CITY OF ALBUQUERQUE

**RE: RFK RG Charter School
2006 Bridge Blvd. SW
Grading and Drainage Plans
Engineer's Stamp Date: 05/05/2025
Hydrology File: L12D024
Case # HYDR-2025-00163**

FEMA MAP

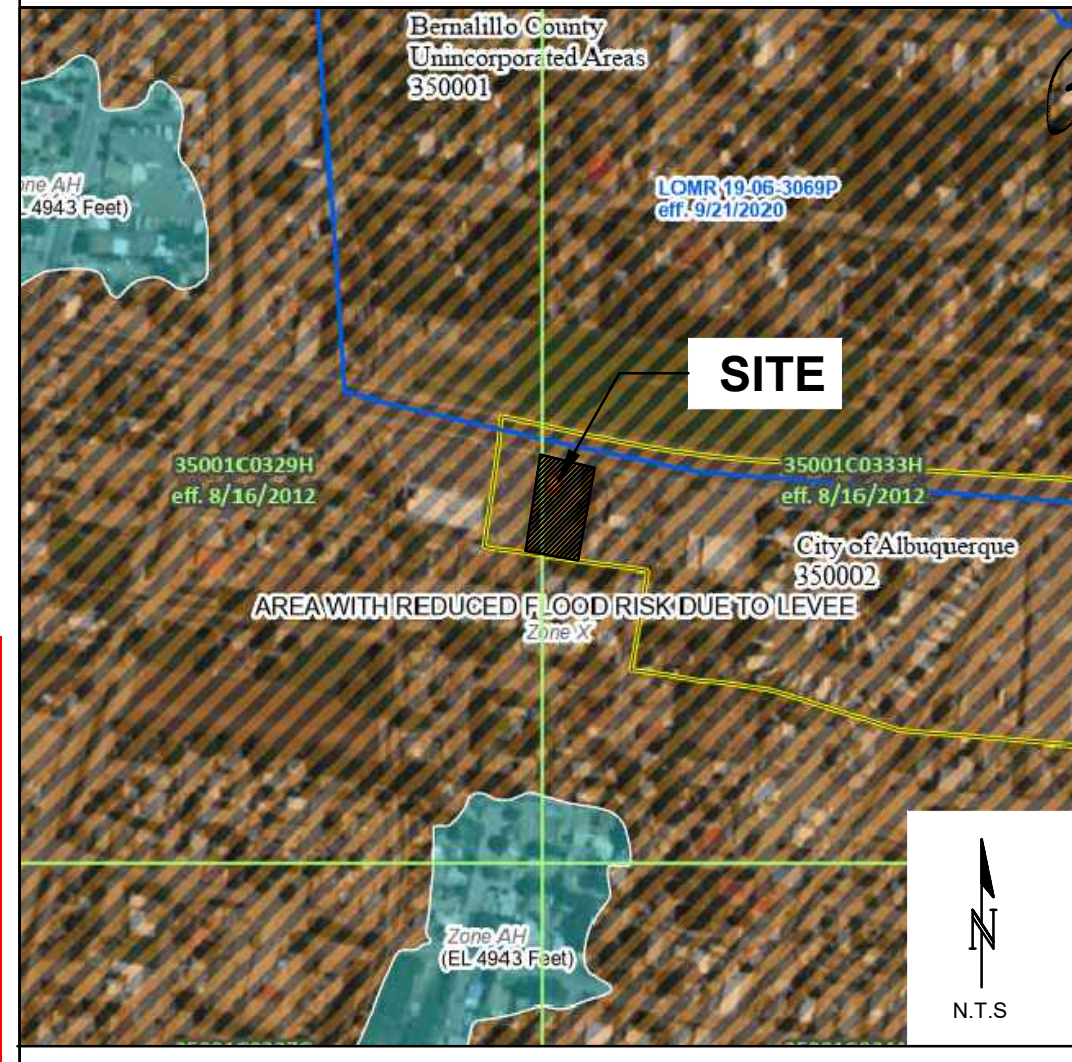
1. Provide a clearer FIRM map, the provided map is difficult to view the property location.
2. Provide additional information within the write-up discussing what is existing and proposed conditions.

SHEET NUMBER
CG-101

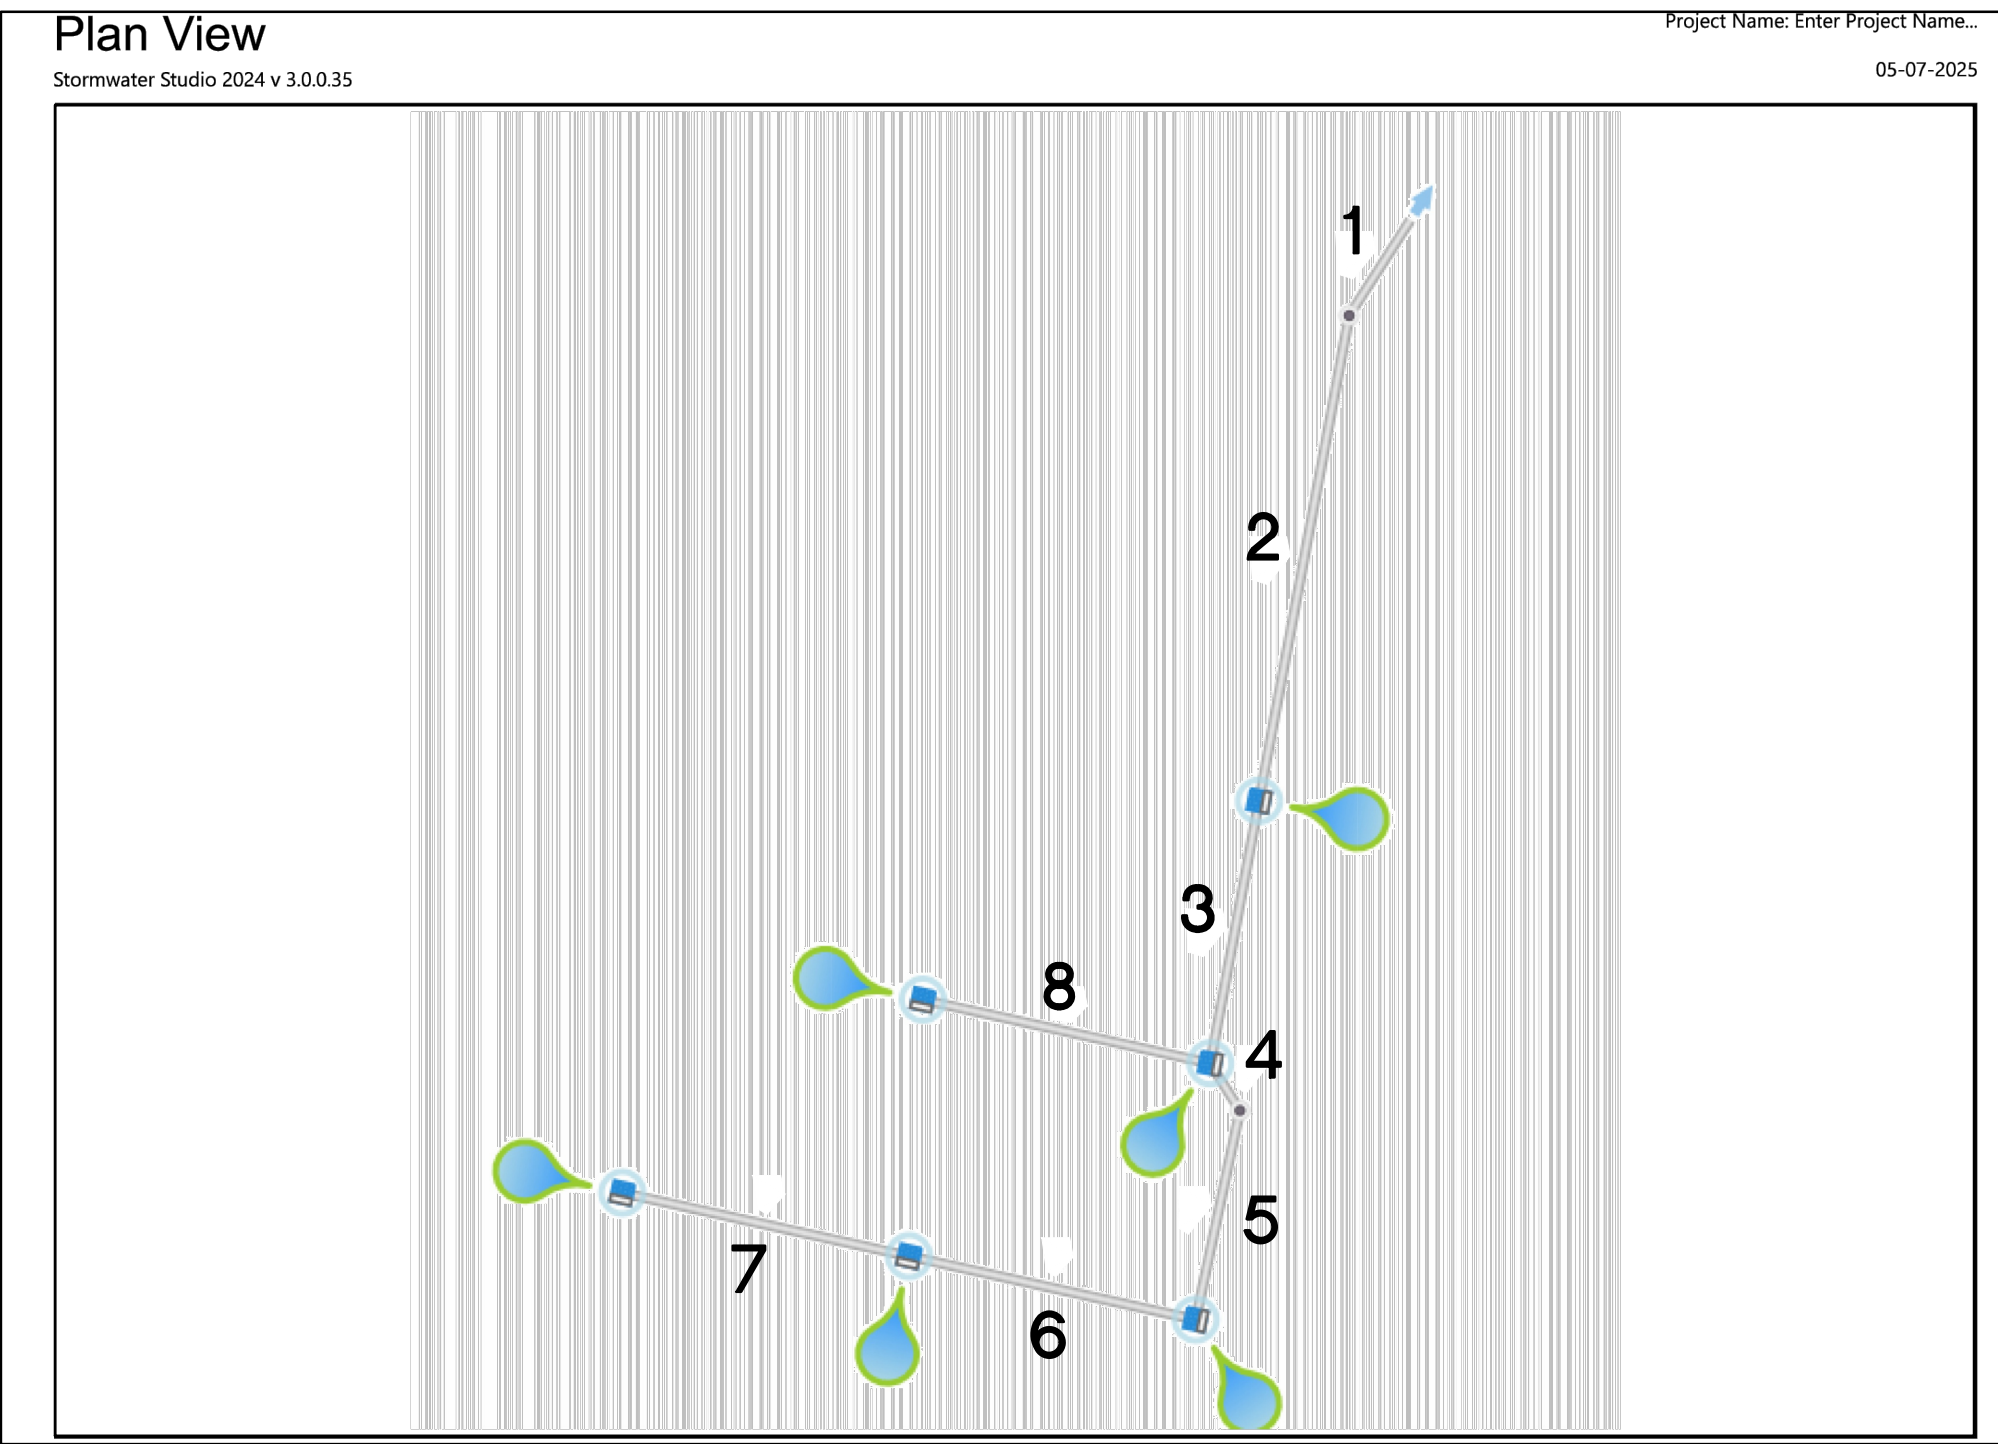
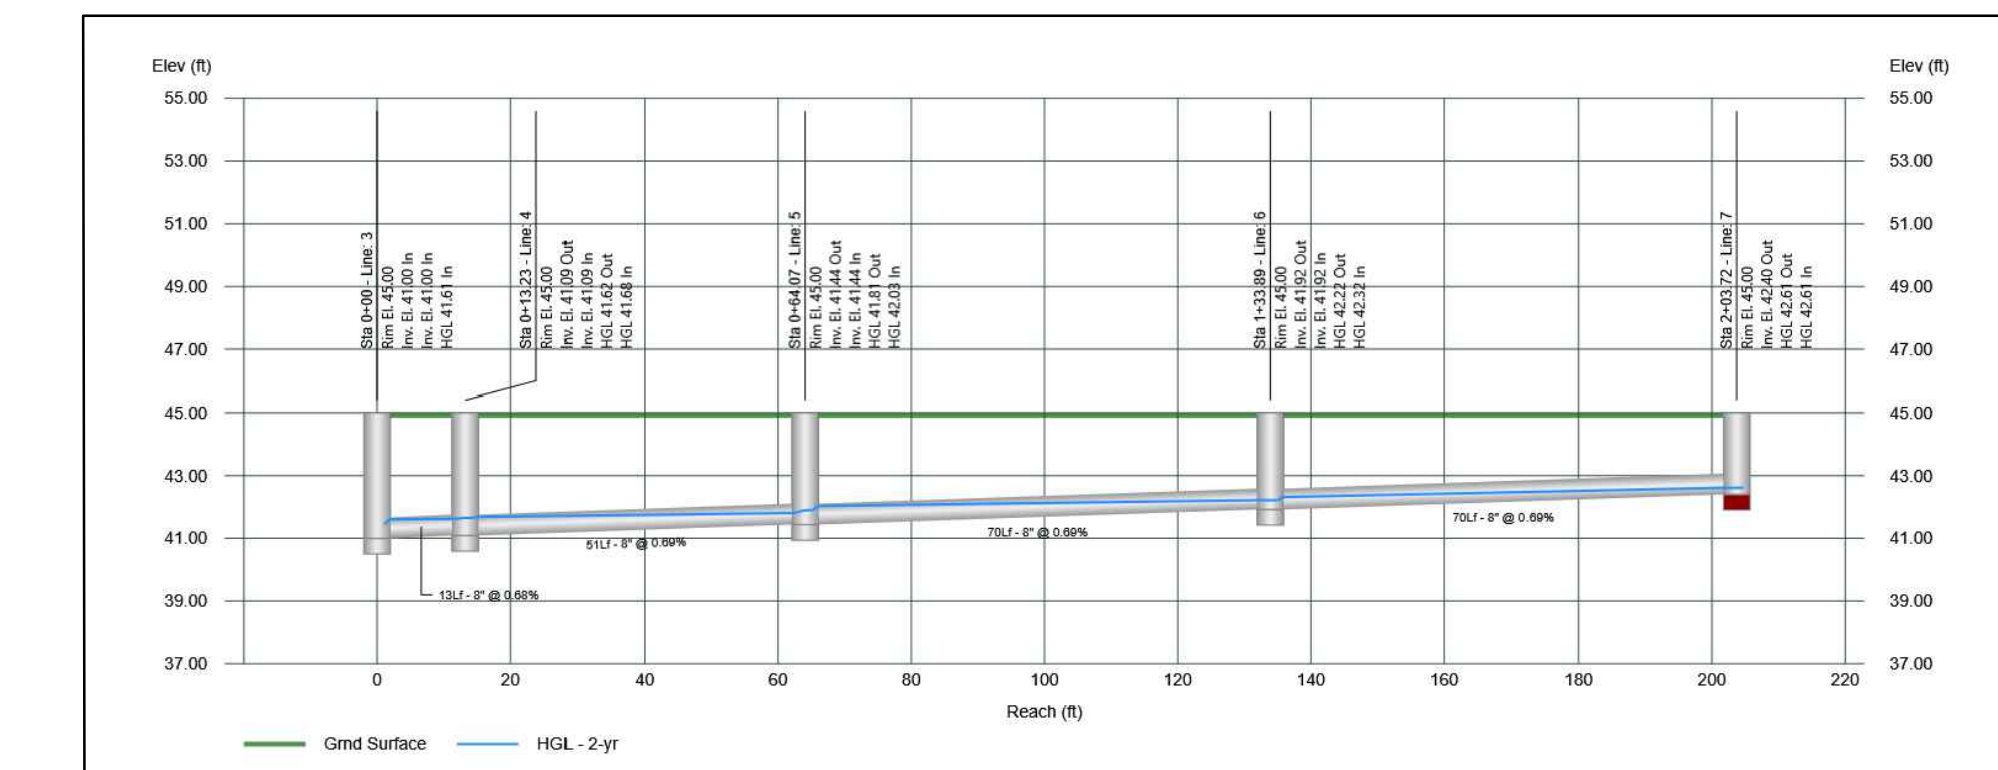
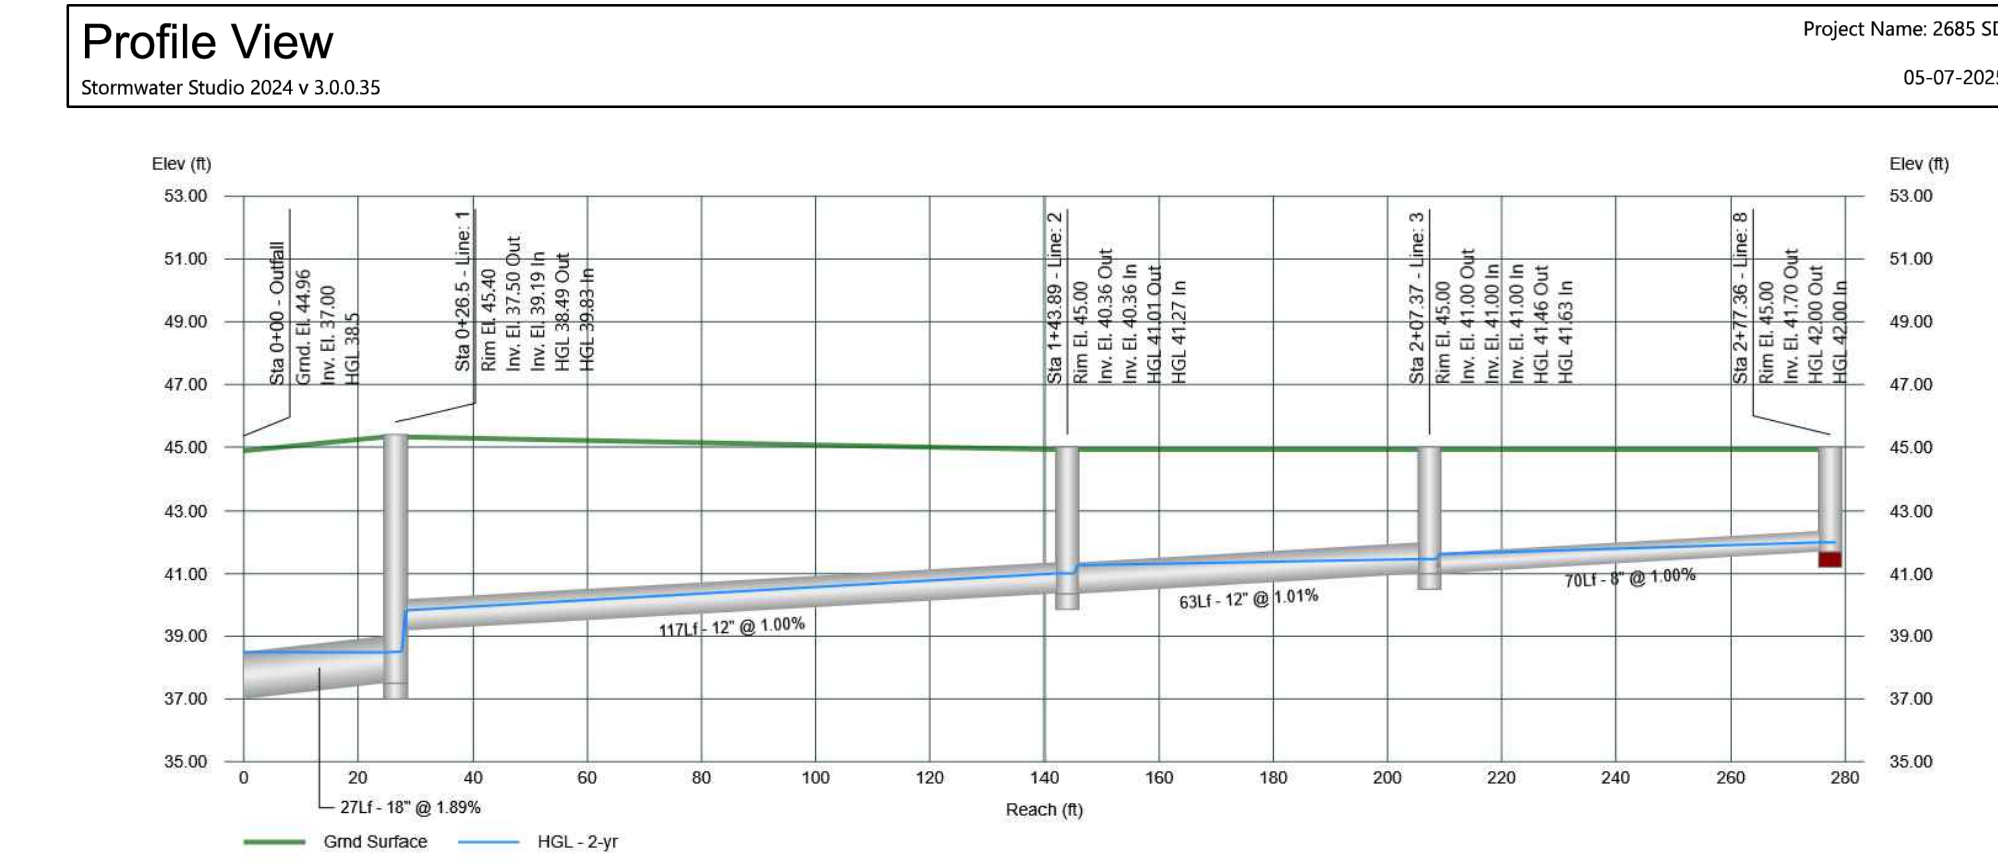
3. The SD plan and profiles have background shadows that make it difficult to view the actual text, please remove.
4. Provide the County documentation that the Bridge SD limitations, discharge per acre.

5. Provide inverts of the tie-in to the Bridge SD.
6. Construction plans will be required for the work within the County right of way. Also, there may be limitations on the disturbance of a project that utilized Federal funds.

7. If there is a limit to the Bridge SD, then a constrictor plate may be the best option at the last manhole prior to discharging into the 18 inch SD.
8. The plan above the EGL table, show the pipe label according to the respective pipes within the table.

9. On the profile sheet, show the 18-inch pipe all the way to the Bridge SD.
10. Are there walls along the property lines that prevent offsite flows from entering the property?
